FINAL DESIGN REPORT FOR SAND CREEK RESTORATION

July 25, 2023

Mixed Flow Analysis for GSB Design

Sub-critical flow analysis for Shear/Velocity evaluation of Naturalized Channel Design

SAND CREEK RESTORATION WORK MAP

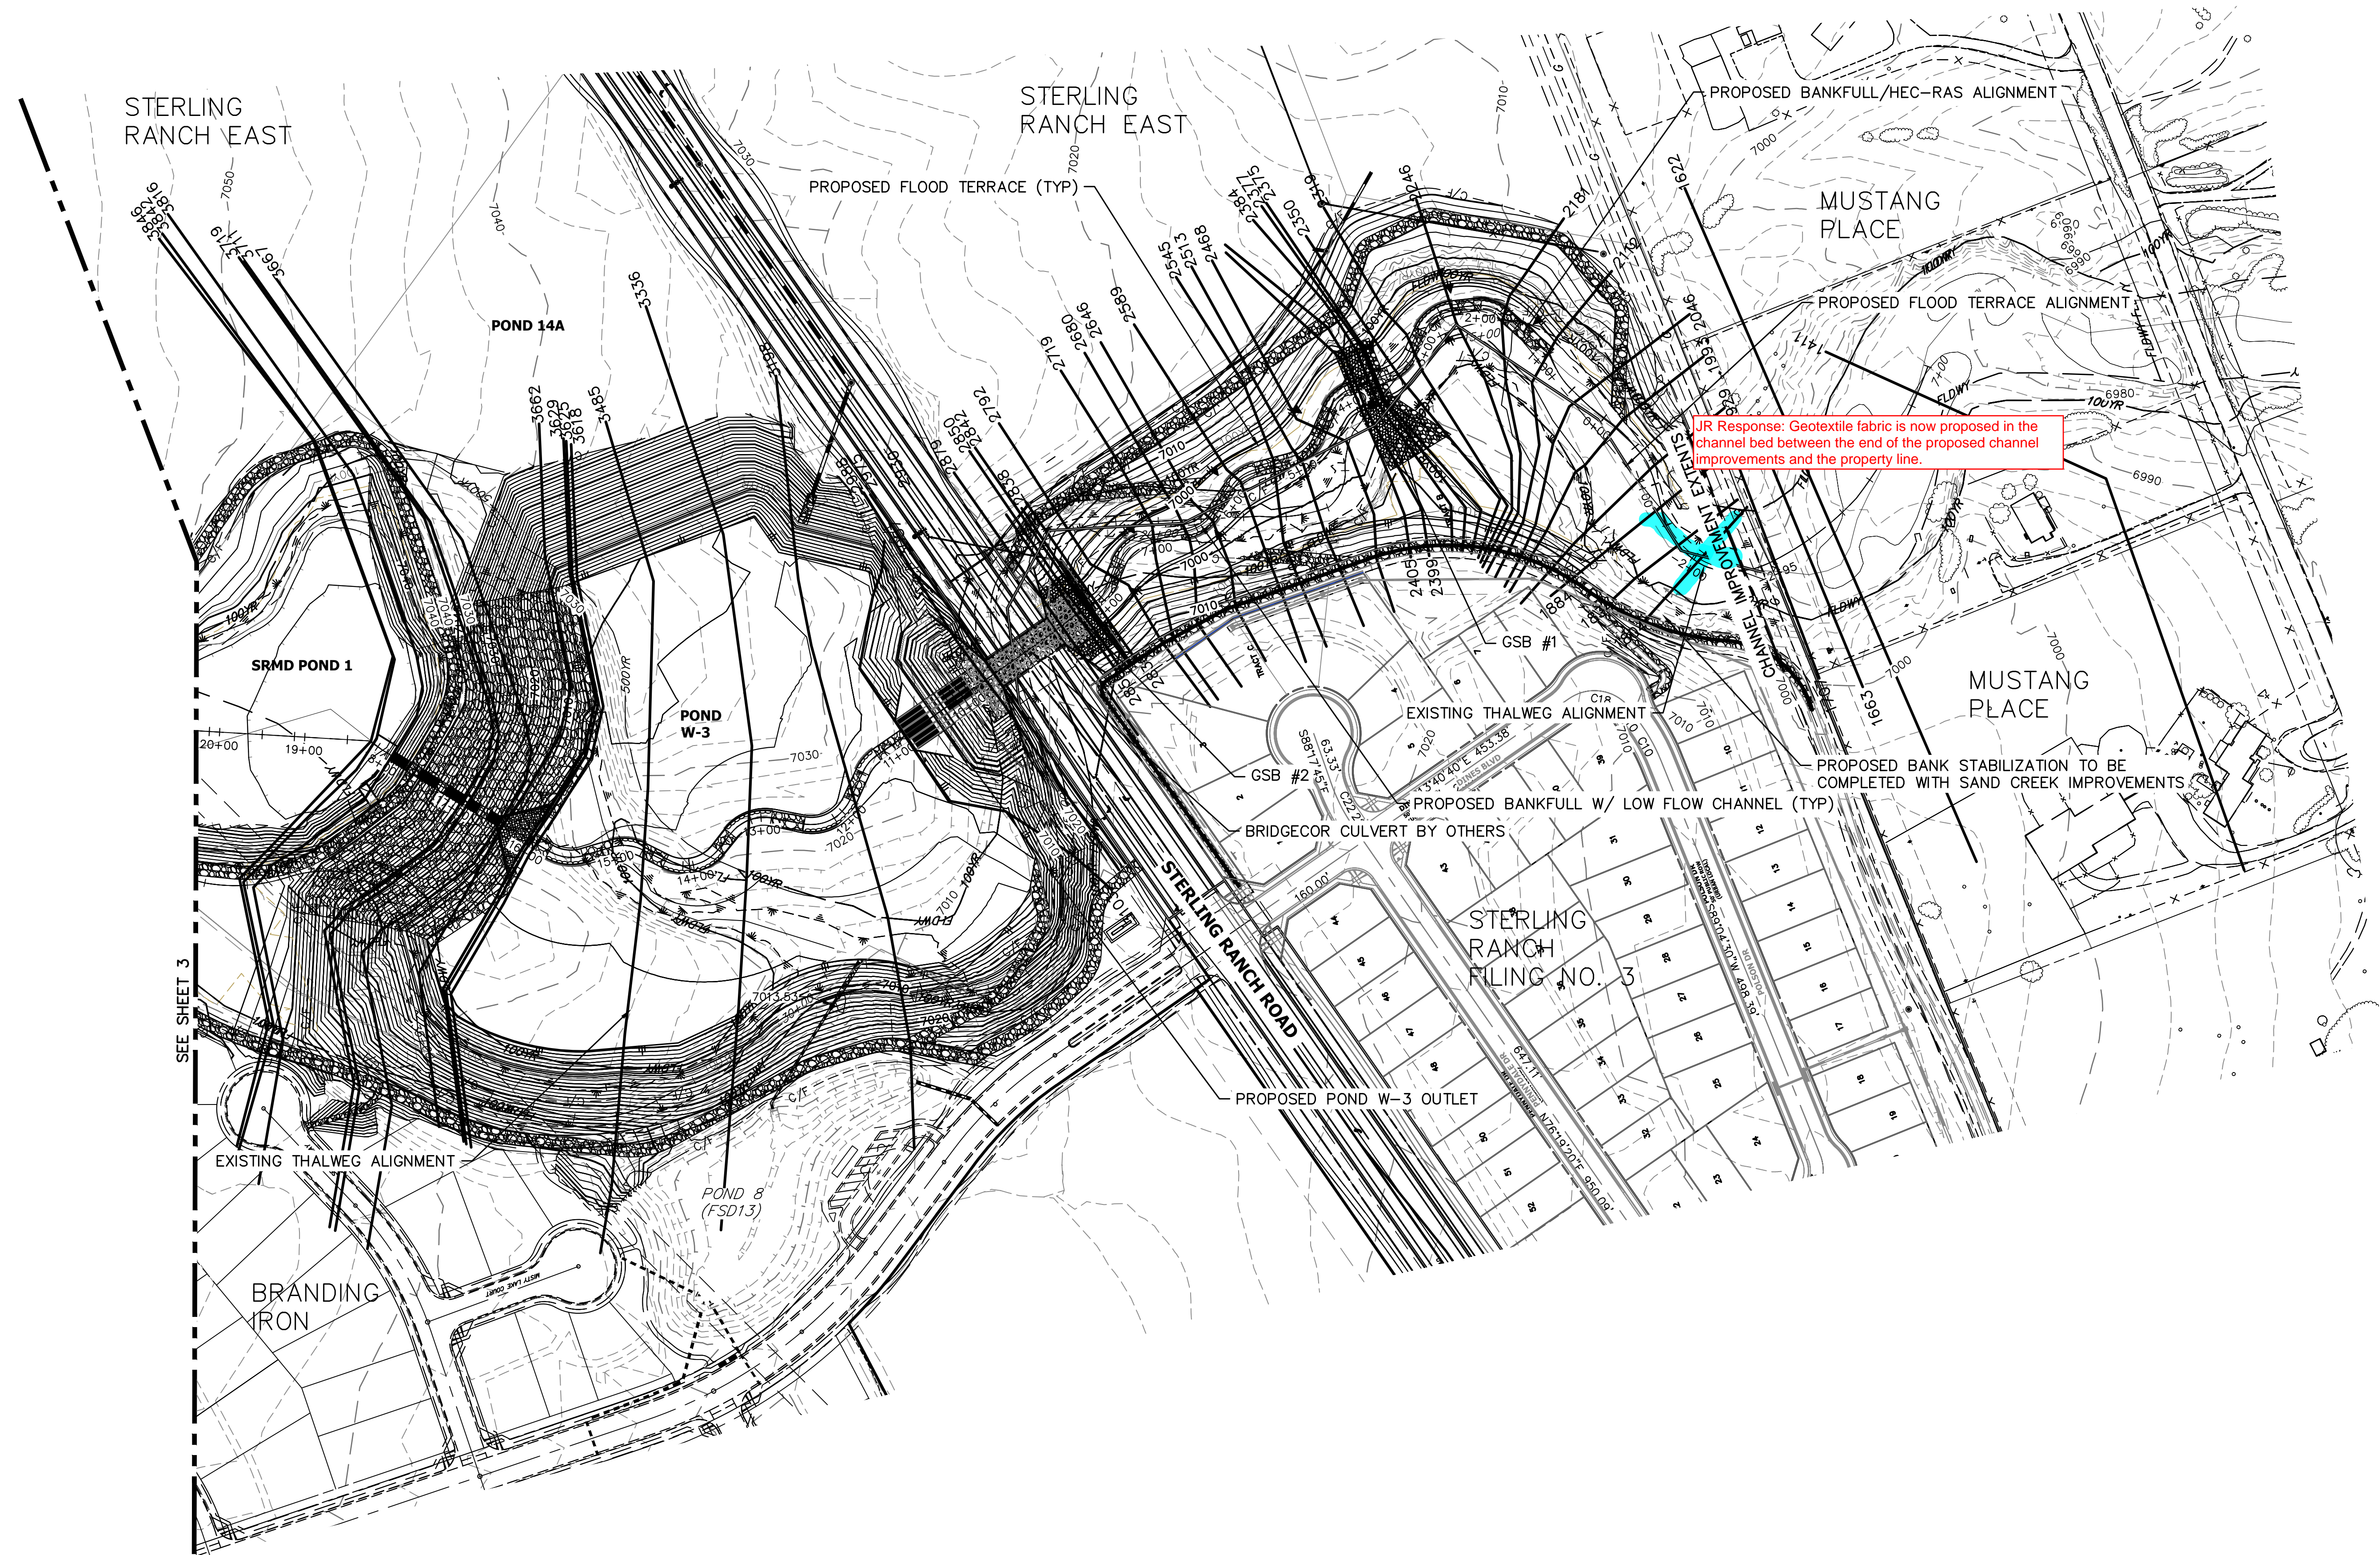
JR Response: Line has been frozen.
Is this a check structure?
